Submission for Job: #6011 SSD 6011 - Mixed use residential development within the South West Plot
https://majorprojects.affinitylive.com/?action=view_job&id=6011

Site: #2825 SICEEP Site, The Haymarket; Darling Drive, Sydney
https://majorprojects.affinitylive.com/?action=view_site&id=2825

SSD 6011 - Mixed use residential development within the South West Plot

2 August 2013

## Winter Solstice (21<sup>st</sup> June)

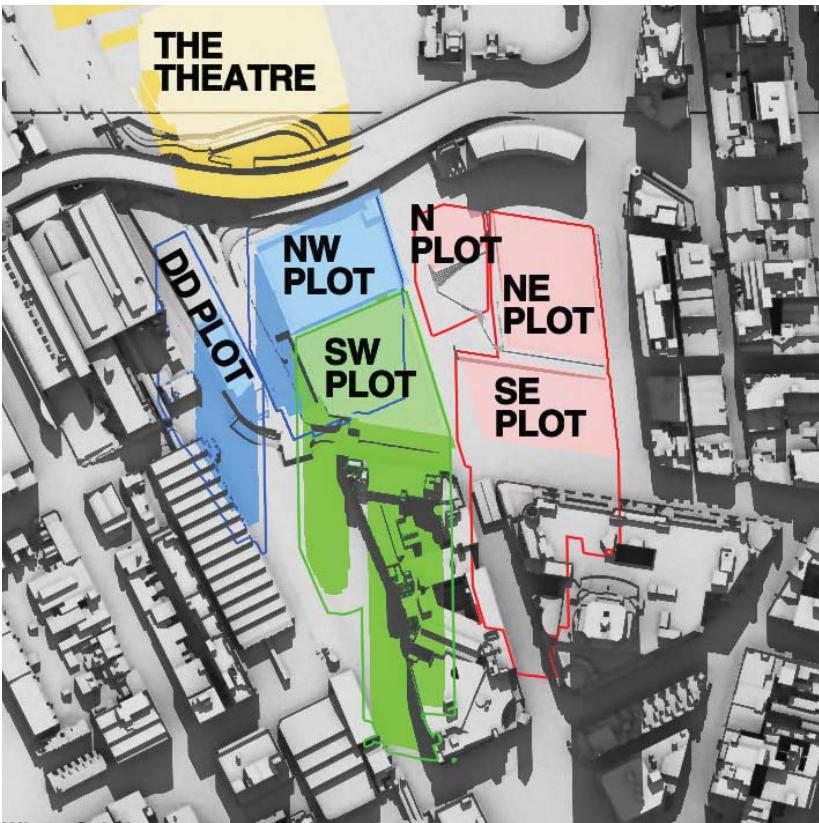
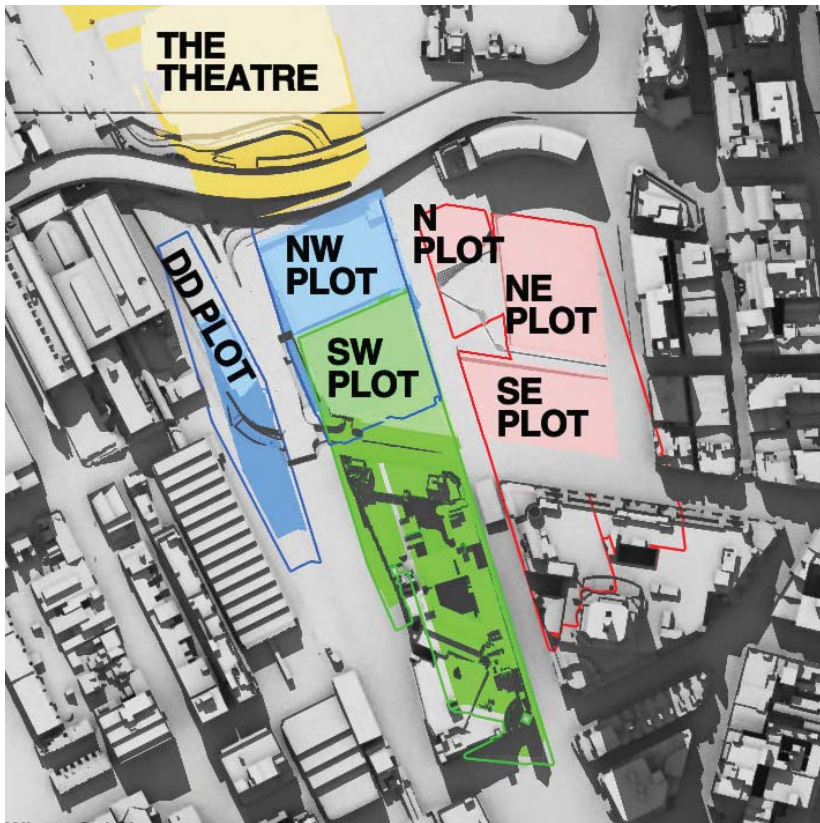
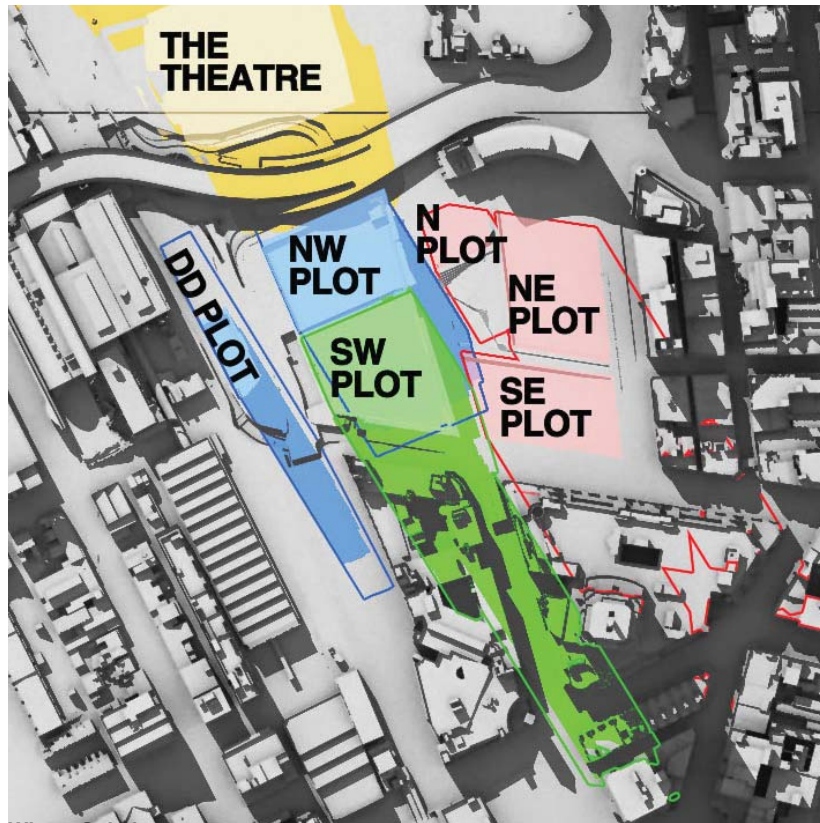
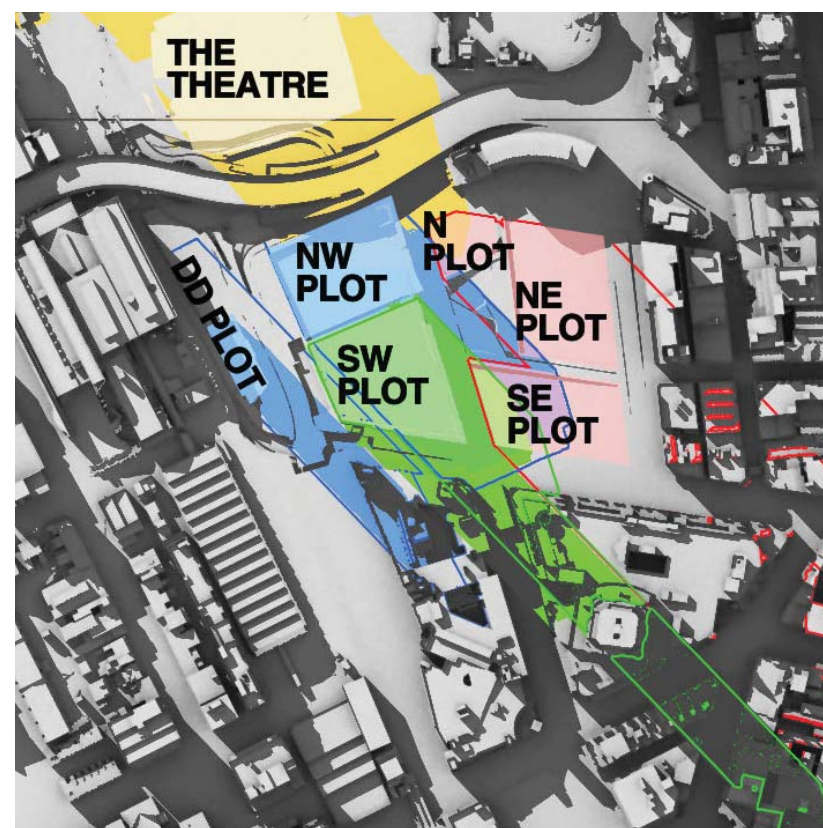
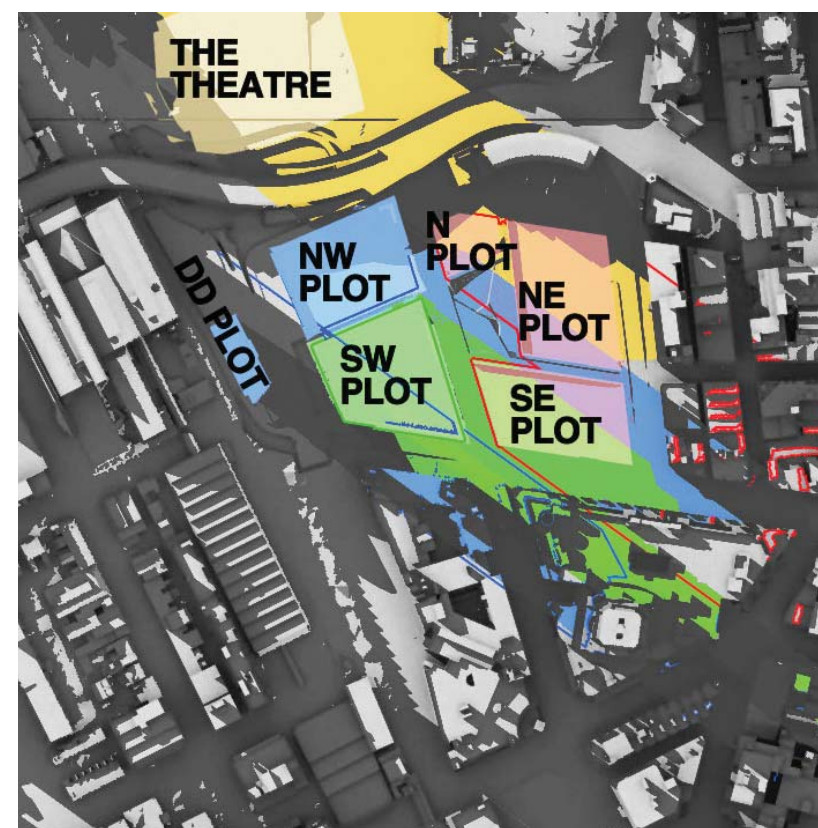
We refer to the shadow diagrams in SSD5878, Appendix H. Supplementary Design Report, Section 6. Amendments, Winter solstice - 22 June. This is not 21 June, but there would be no noticeable difference.

At 9am, 10am and 11am the west façade is totally in shadow due to other parts of The Peak building itself.

At 12pm there is still substantial existing shadowing on the west façade caused by the irregular shape of the west facade.

At 1pm the existing shadowing has been substantially removed, but not totally removed.

It can be concluded that some single aspect apartments on the west façade and some south-west dual aspect corner apartments currently receive less than 2 hours direct sunlight to habitable rooms and 50% of the private open space between 9am and 3pm on 21 June.

By 2pm the existing shadowing has been totally removed, but that is too late to achieve two hours of direct sunlight before 3pm.

At 9am, 10am and 11am the west façade is totally in shadow due to other parts of The Peak building itself.

At 12pm there is still substantial existing shadowing on the west façade caused by the irregular shape of the west facade.

At 1pm the existing shadowing has been substantially, although not entirely, removed. However, overshadowing of lower levels of the west façade by the concept proposal parameter plan shadows for the N,NE and SE plots has already started.

By 2pm the existing shadowing has been totally removed. However, overshadowing of the west façade by the SSDA4 and SSDA5 buildings has appeared and risen further up the west façade than the concept proposal parameter plan shadows for the N,NE and SE plots, which is still present.

At 3pm, the proponent states correctly that 45-45% of the western façade is overshadowed by the SSDA4 and SSDA5 buildings.

It can be concluded that, as a result of combination of the proposed development with existing shadowing of the west façade, some single aspect apartments on the west façade and the south-west dual aspect corner apartments which currently receive less than 2 hours direct sunlight to habitable rooms and 50% of the private open space between 9am and 3pm on 21 June will suffer additional overshadowing. It is beyond our skills to count the number of such apartments. We note that the proponent has made no attempt to do so.

Rather than counting the number of units which will not meet the DCP guidelines, the proponent attempts to trade-off direct sunlight at 4pm for lack of direct sunlight during the period 9am to 3pm. There is no provision in the DCP guidelines for such a trade-off.
